Fire Marshal Division

**Re: Hair Salon with Bathroom
110 S. Railroad St.
Coats, NC 27521**

Application Number BCOM2003-0002

201 FLOOR PLAN
SCALE : 1/4" = 1'-0"

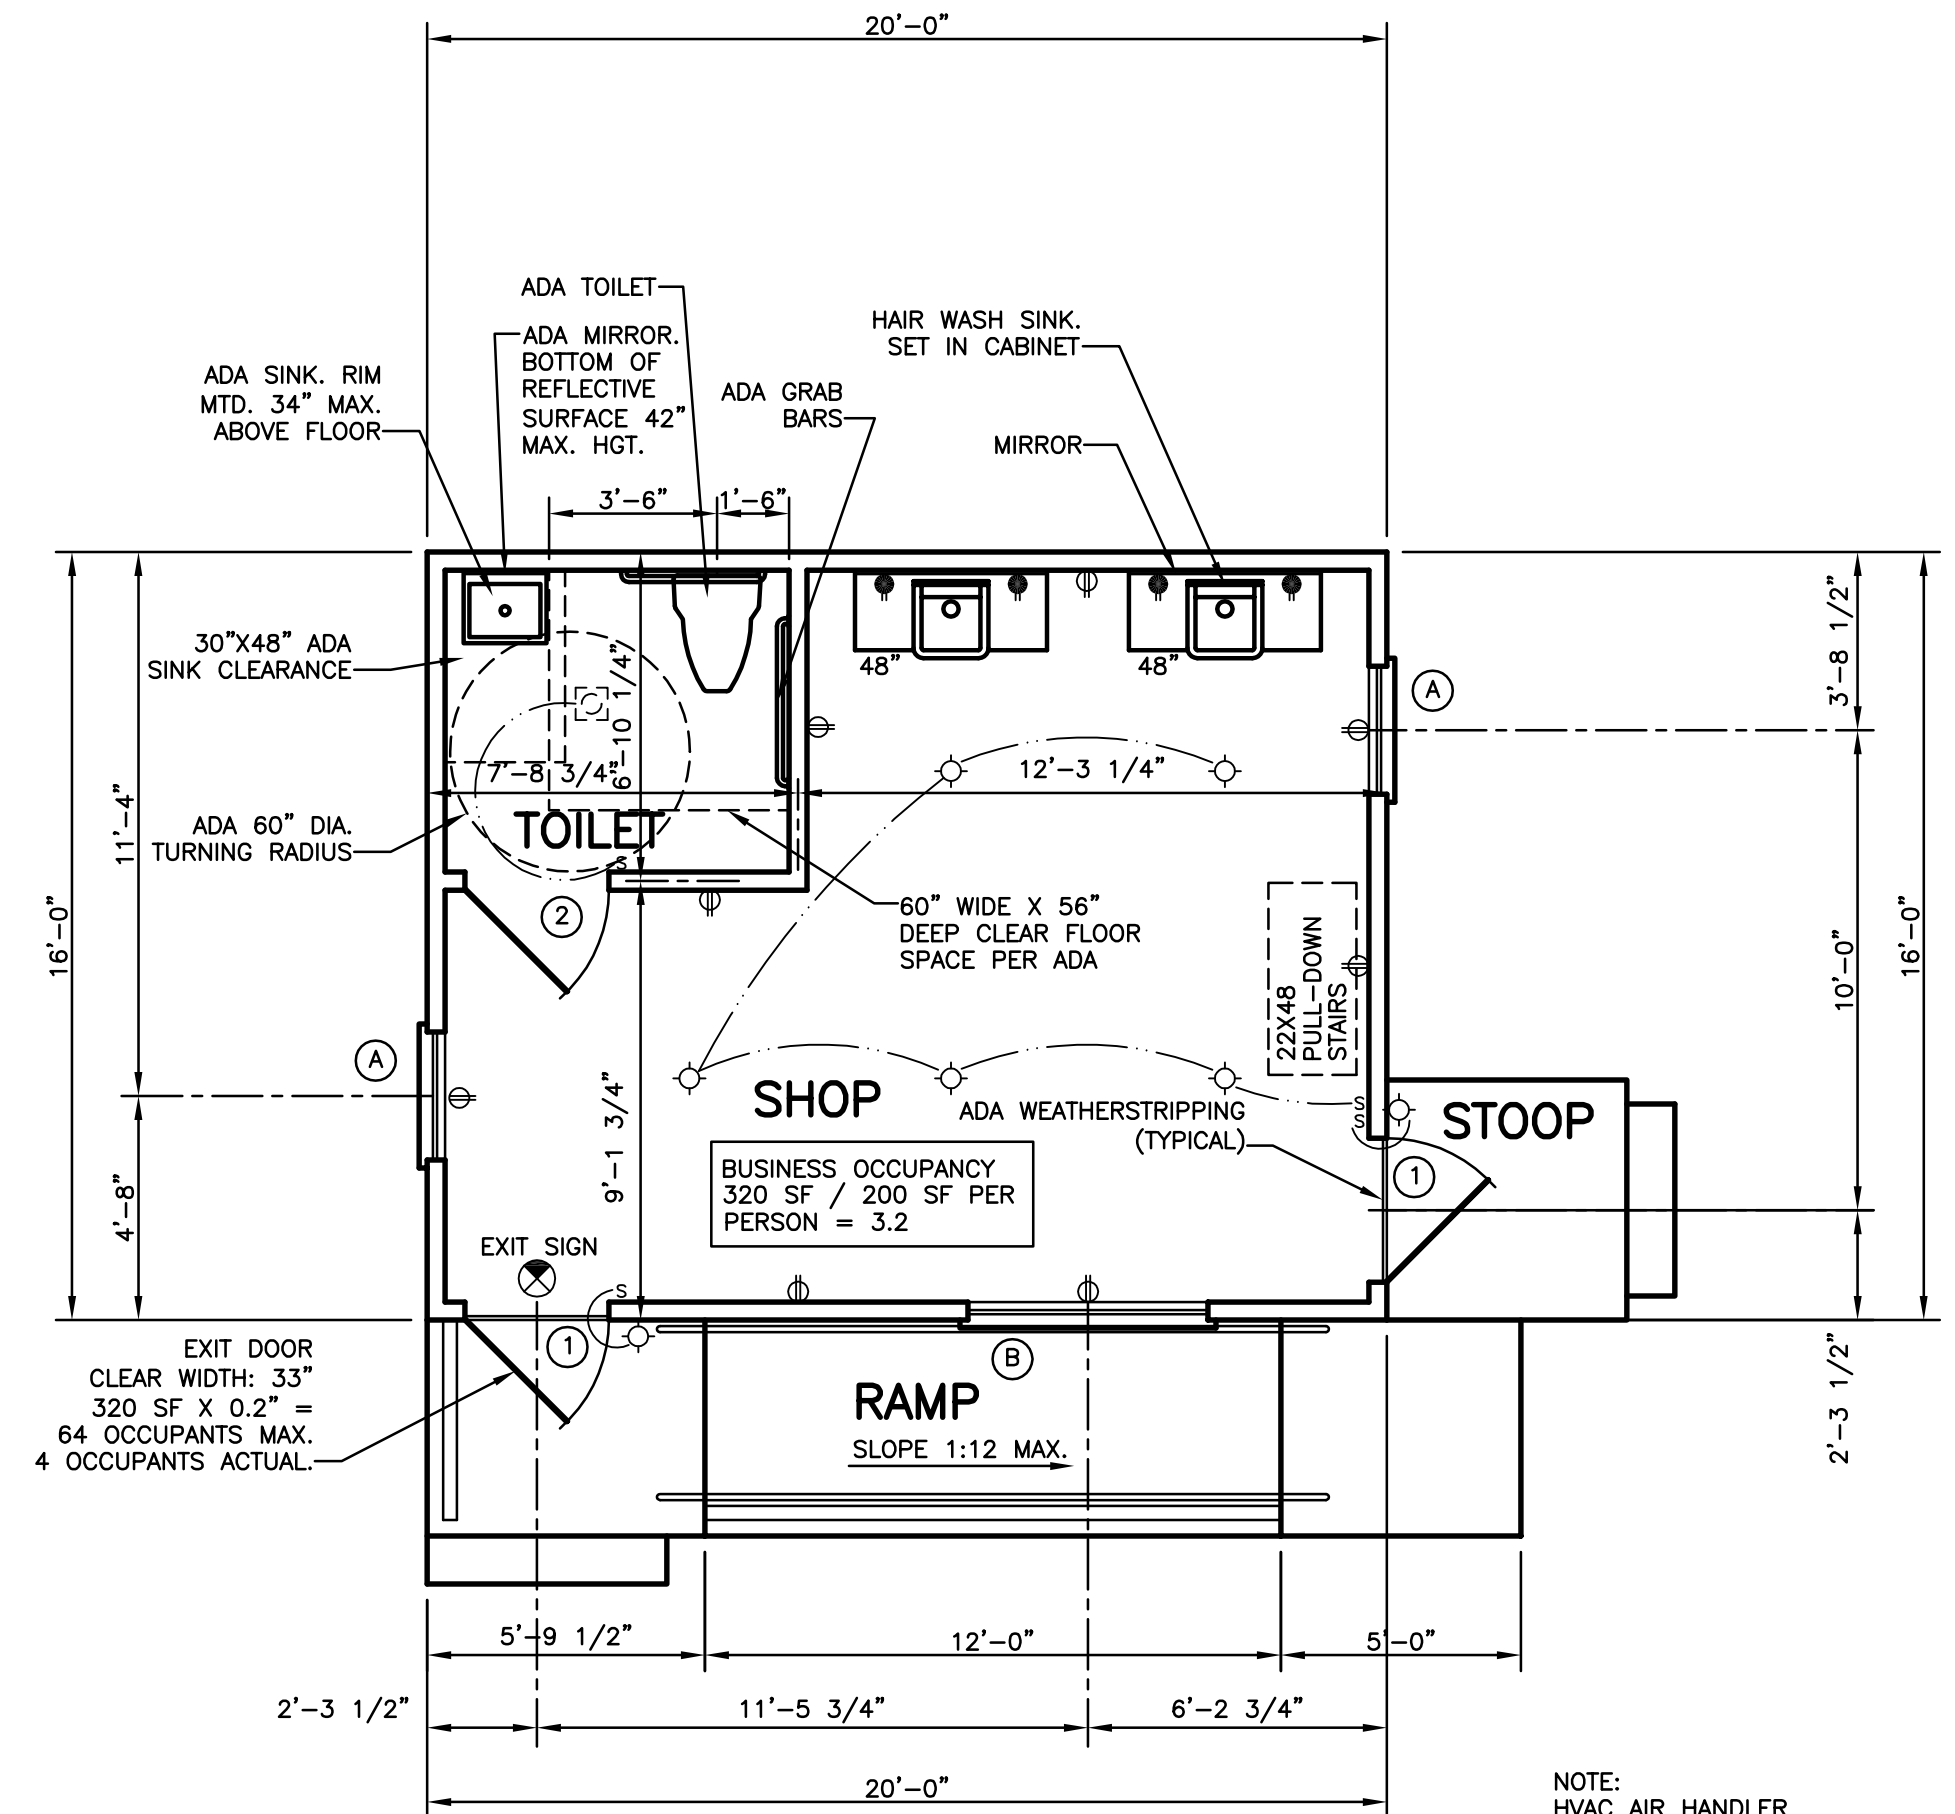
- **906.1 Fire Extinguishers**
 - Minimum of (1) 2A10:BC fire extinguisher shall be installed per 75' distance of travel.
 - All Fire extinguisher shall be properly mounted and tagged by a fire extinguisher company.
